Our ref: NO/2020/112925/02-L01
Your ref: 3/2020/0602
Date: 18 May 2021

CREATION OF ADDITIONAL DINING SPACE, A BAKERY DELI FOOD SALES AREA WITH STORAGE AND OFFICE FACILITIES. ADDITIONAL TERRACE DINING WITH STORAGE BELOW.
HOLDEN CLOUGH NURSERY, BOLTON BY BOWLAND ROAD, BOLTON BY BOWLAND, BB7 4PF

2 Proposed East Elevation
Scale 1:100

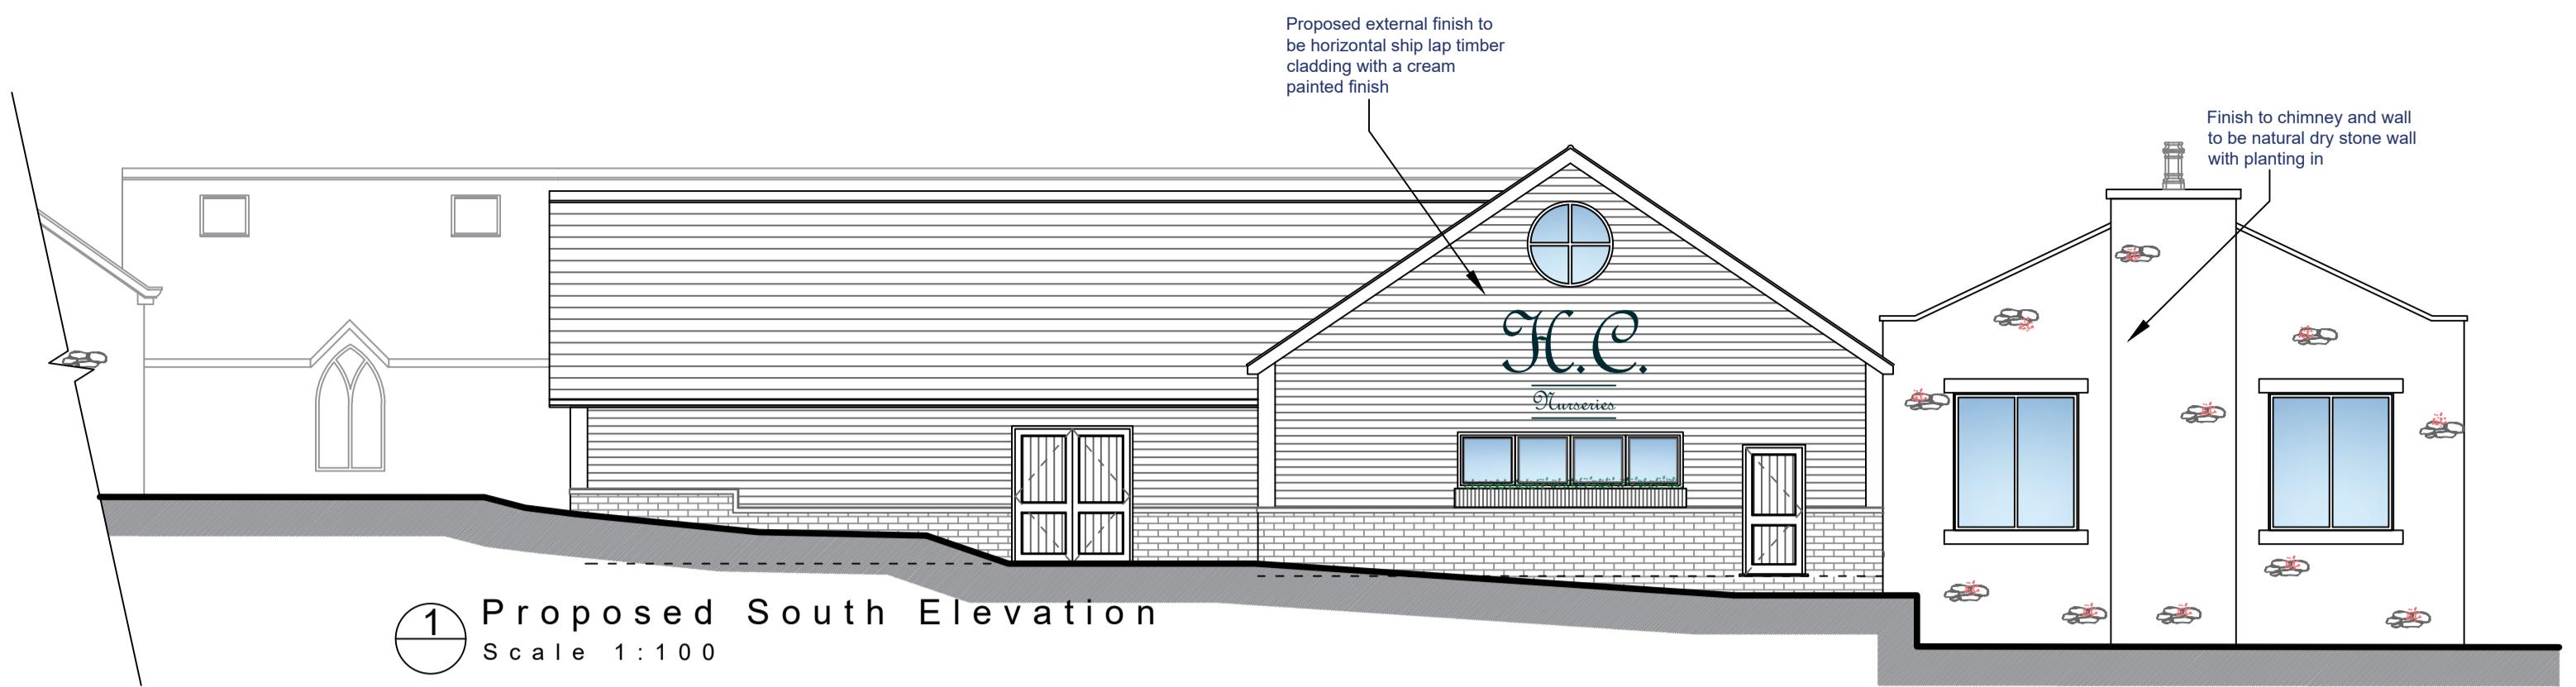
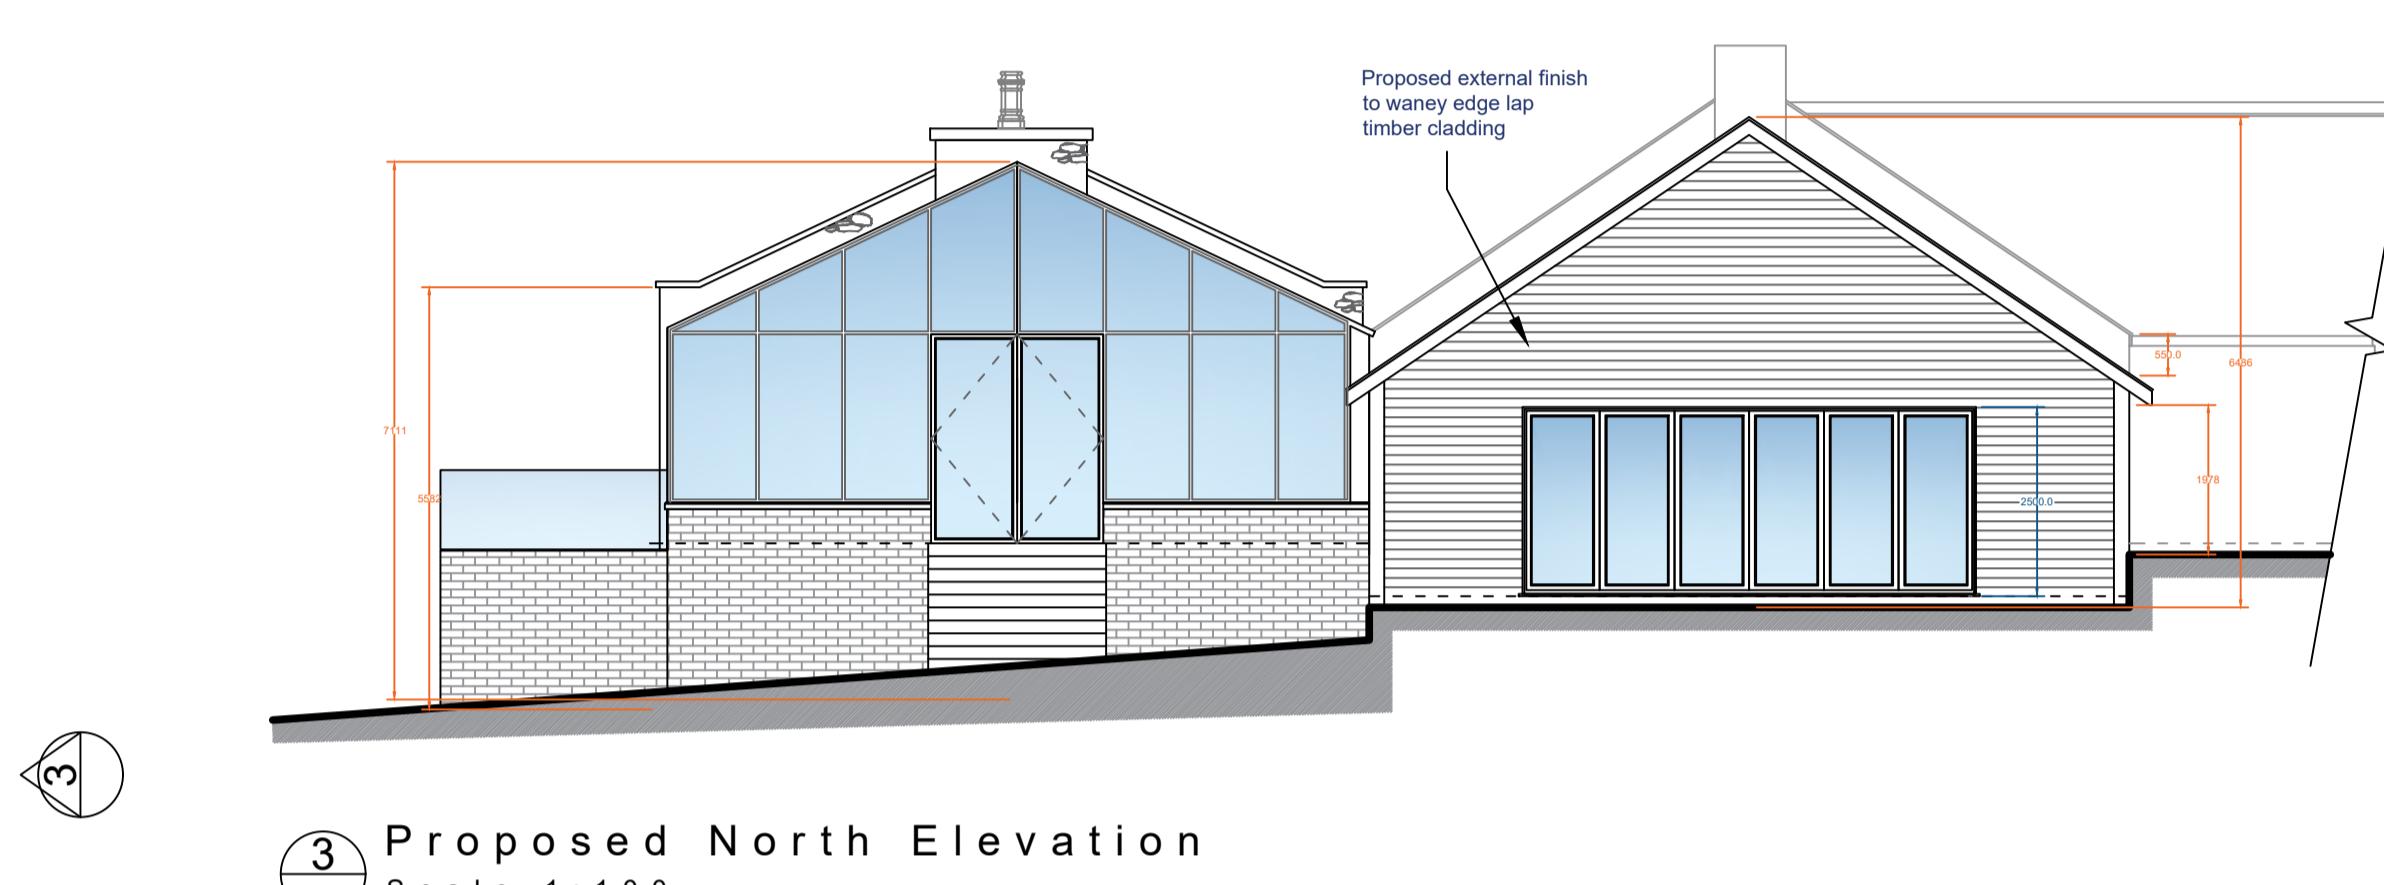
The proposed development to the east side of the building will be at risk of fluvial flooding, it is understood from information submitted, the ground floor will not be habitable (used for storage) with a terrace associated to the business on the first floor. Whilst not mentioned within the FRA, the proposed and existing elevations appear to show that there will be ground level raising within the 1% AEP plus climate change allowance extent, the impact of this has not been assessed.

- The proposed and existing elevations show that there is likely to be ground level alterations within the 1% AEP plus climate change extent which have not been assessed. Raising of ground levels within the flood plain would result in loss of flood plain storage which is likely to increase flood risk elsewhere. This would be contrary to Paragraph 155 of the NPPF. Please confirm whether ground levels will be raised, if so, this must be assessed within the FRA, including the extent and impact of any loss of flood plain storage. If this is proposed, compensatory storage must be provided on a level-for-level basis for the 1% AEP plus allowance for climate change extent.
